SOUTH HOLLAND DISTRICT COUNCIL

To: Planning Committee - 08 March 2023

Purpose: To consider Planning Application H05-1085-22

Description: Erection of a wind fence to produce renewable energy to support the holiday lodges on the site adjacent

title
General Arrangement
Wind Panels

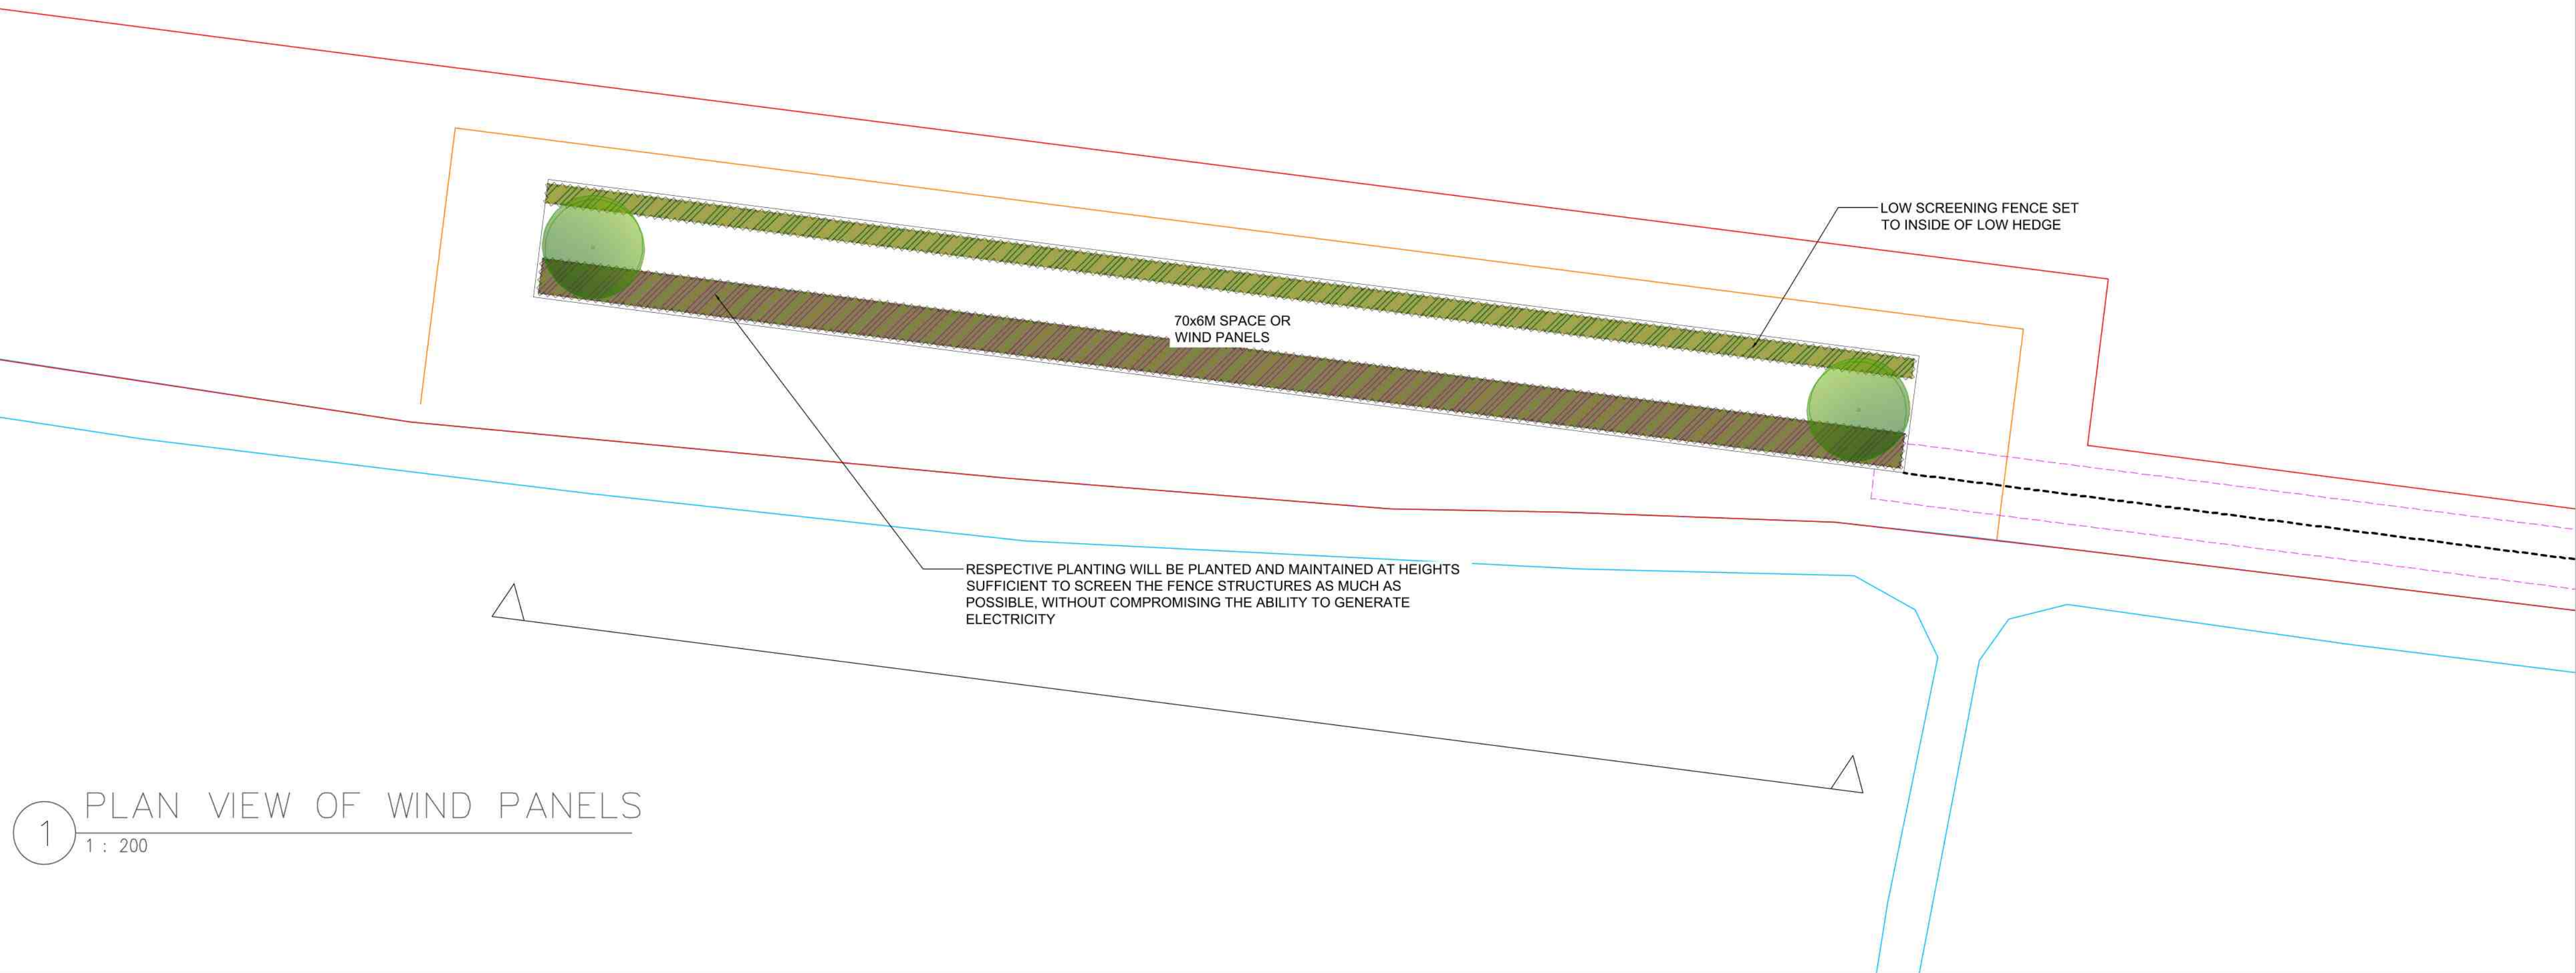
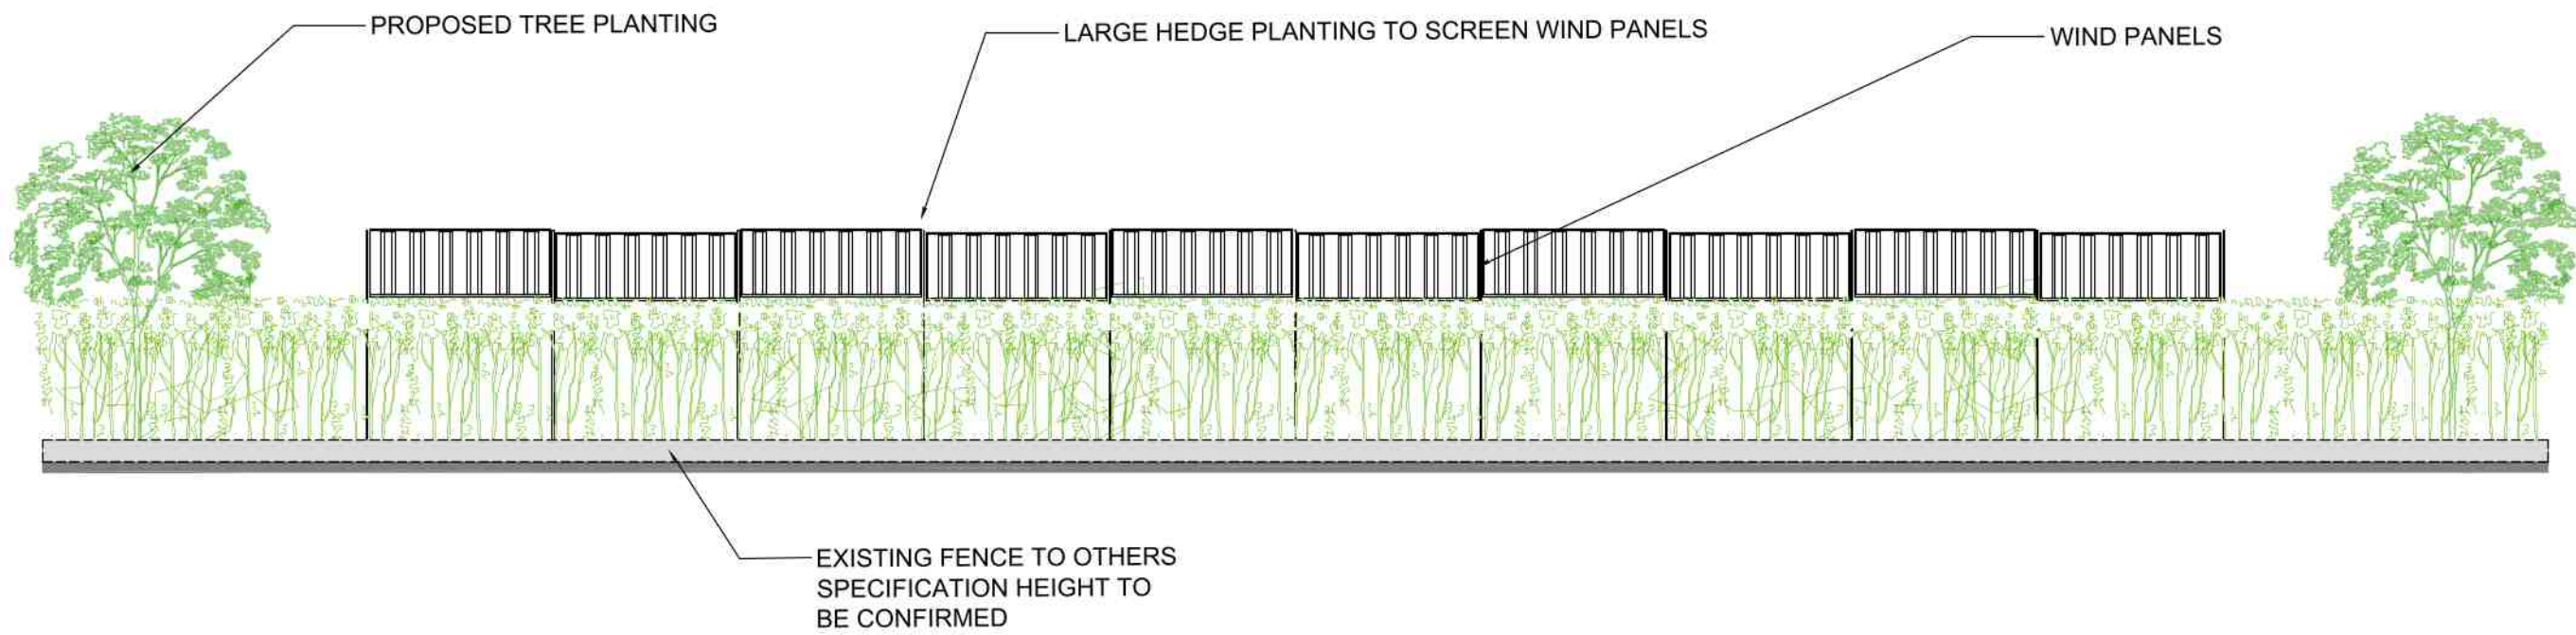
- Concern re surface water drainage and capacity of adjoining watercourses.
- The Taxus Baccata will take 10 years before the height reaches the top of the steel gantries

- This will leave the whole gantry structure area visually exposed
- The Carpinus Betulus will also take 10-20 years before adequate screening coverage is attained

- 7.13 The panels would be visible from Winslow Gate to the west/south-west/north-west and Roman Bank to the north. From the north and south-westerly direction they would be viewed against the backdrop of well established trees / vegetation. Officers did have concerns that the length and height of the wind fence, coupled with it being sited on an open boundary between fields would render it overly obtrusive however, during the course of the application, the plans have been amended to introduce planting around and up from the base of the fence, which would go some way toward the fence being better absorbed into the landscape when considering the backdrop of trees north and south. The wind fence would not be visible from the public realm to the east.

- 7.15 It is very much an on balance judgment but, overall, it is the opinion of officers that the proposed planting would minimise the visual impact of the proposed wind fence on the landscape to such an extent that it would be acceptable. It is therefore concluded that the proposed development satisfactorily complies with Policies 2 and 3 of the Local Plan in landscape / visual terms. Policy 2 of the Local Plan requires development proposals to take into account sustainable development considerations such as: quality of design; and size, scale, layout, density, impact on character and appearance of the area and the relationship to existing development. Policy 3 requires development proposals to respect the landscape character of the location.

4. The planting shown on dwg. no. 05-1071-302 rev P03 shall be undertaken and completed before the development is first brought into use and retained thereafter.
